**WELWYN HATFIELD BOROUGH COUNCIL
ASSISTANT DIRECTOR (PLANNING)**

DELEGATED APPLICATION

Application No: 6/2019/1101/FULL
Location: Ocado Ltd Gypsy Moth Avenue Hatfield AL10 9BD
Proposal: Erection of an ancillary staff shop following demolition of an existing cabin building
Officer:

Recommendation: Granted

ELEVATION 4
 SCALE 1:50

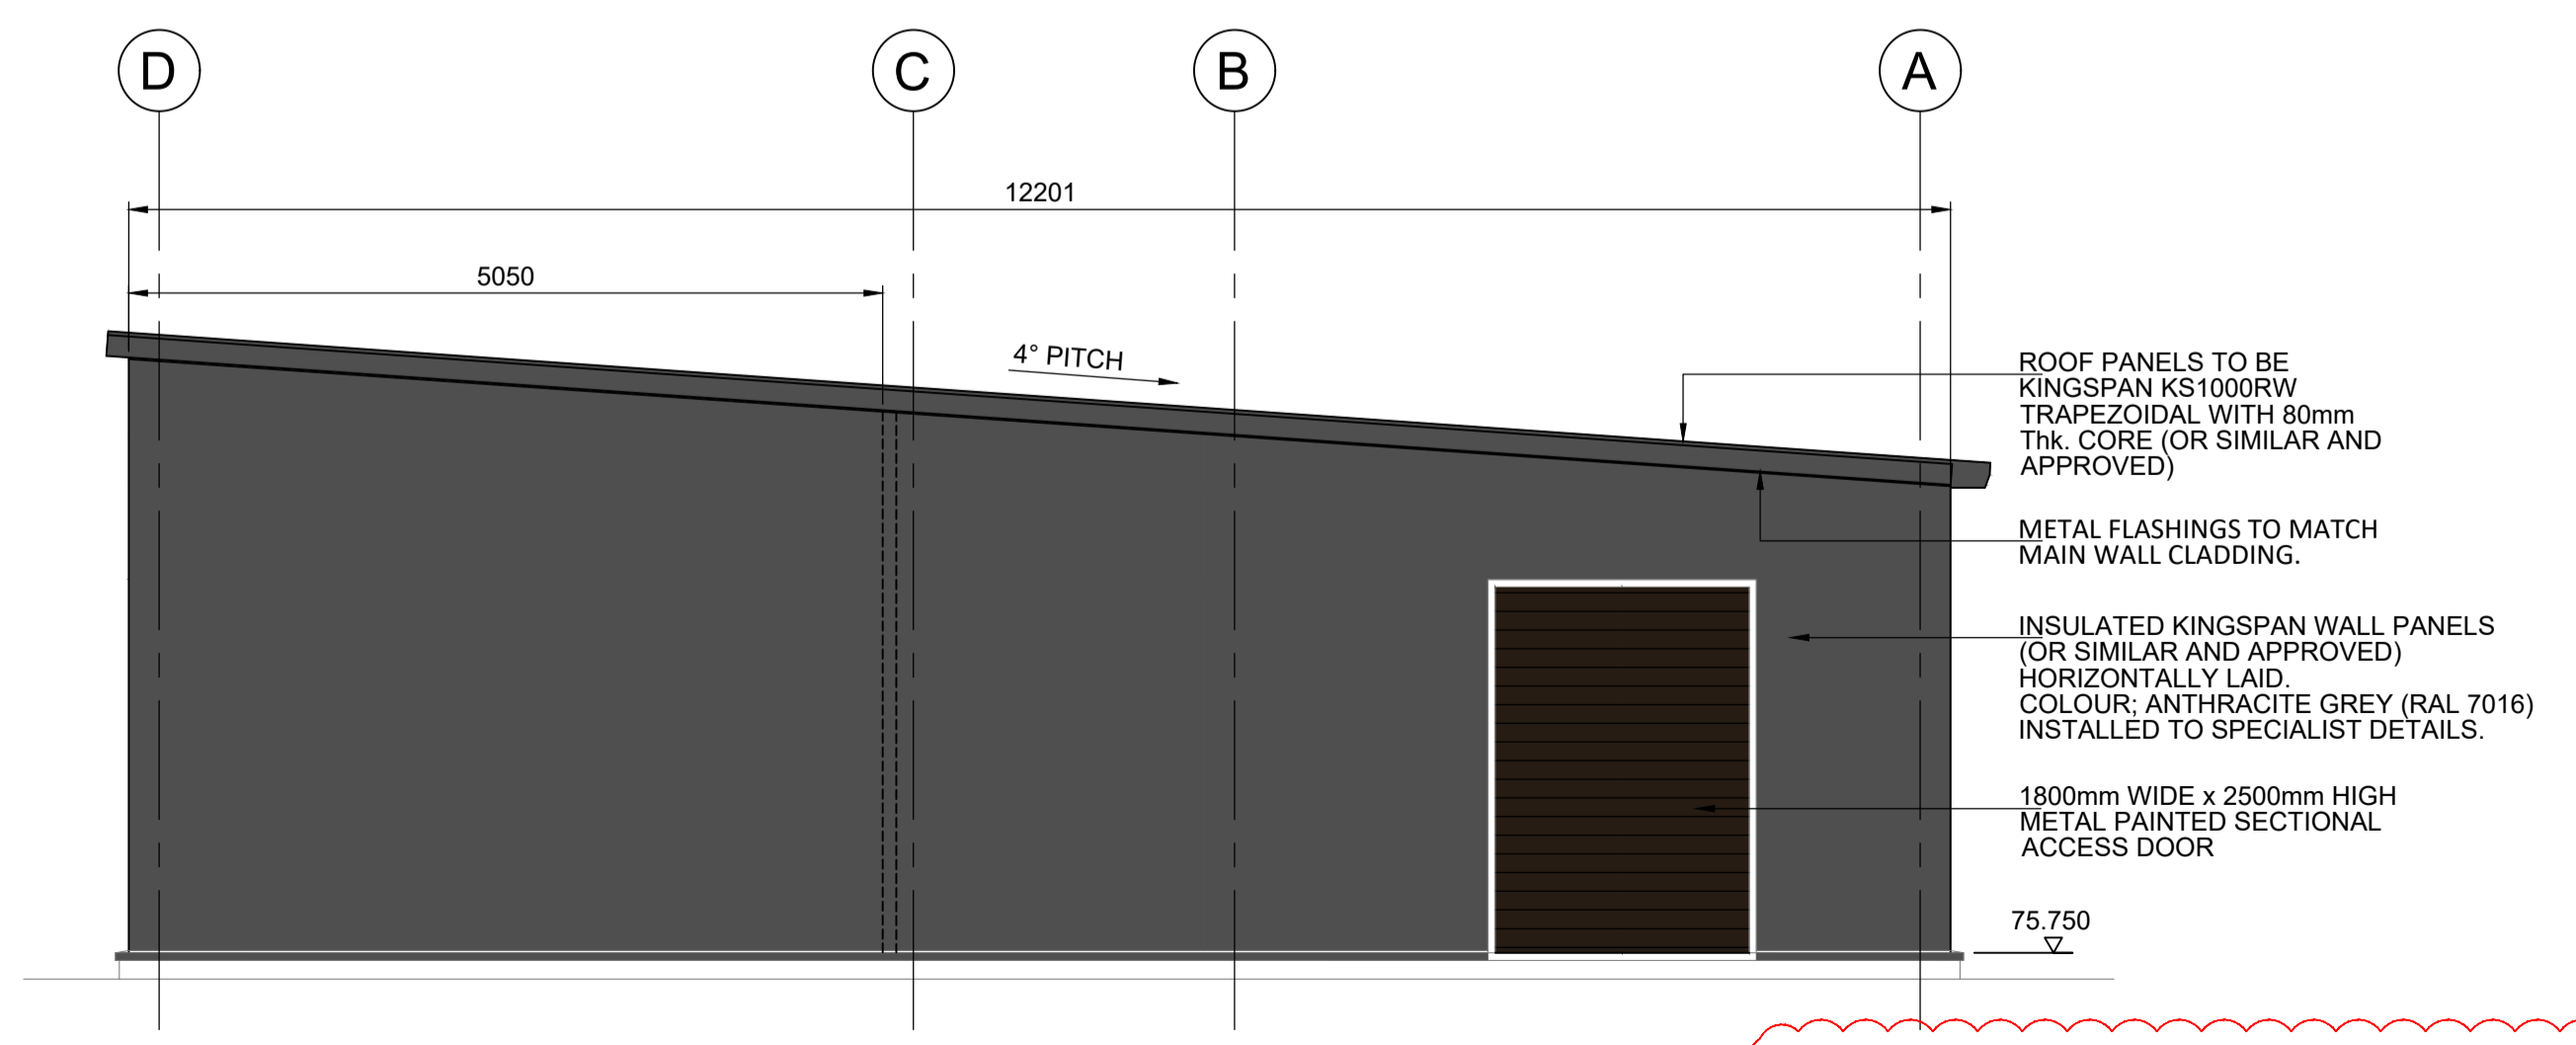
Comment (if applicable): The proposed building is mainly rectangle in shape and has a small projection to the north that is proposed to be used as a shop entrance. The unit would measure approximately 154 sqm located on an area of hard surface. It would have a mono-pitched roof measuring 4.15 metres at its top. The proposed development would be clad with anthracite grey kingspan wall and roof panels.

While it is acknowledged that the proposed building has a footprint wider than the existing cabin, it is overall considered that the siting and scale of the proposed unit would not appear intrusive or out of keeping within the context of the Business Park. Furthermore, the design and materials are considered to be reflective of the character and appearance of the site.
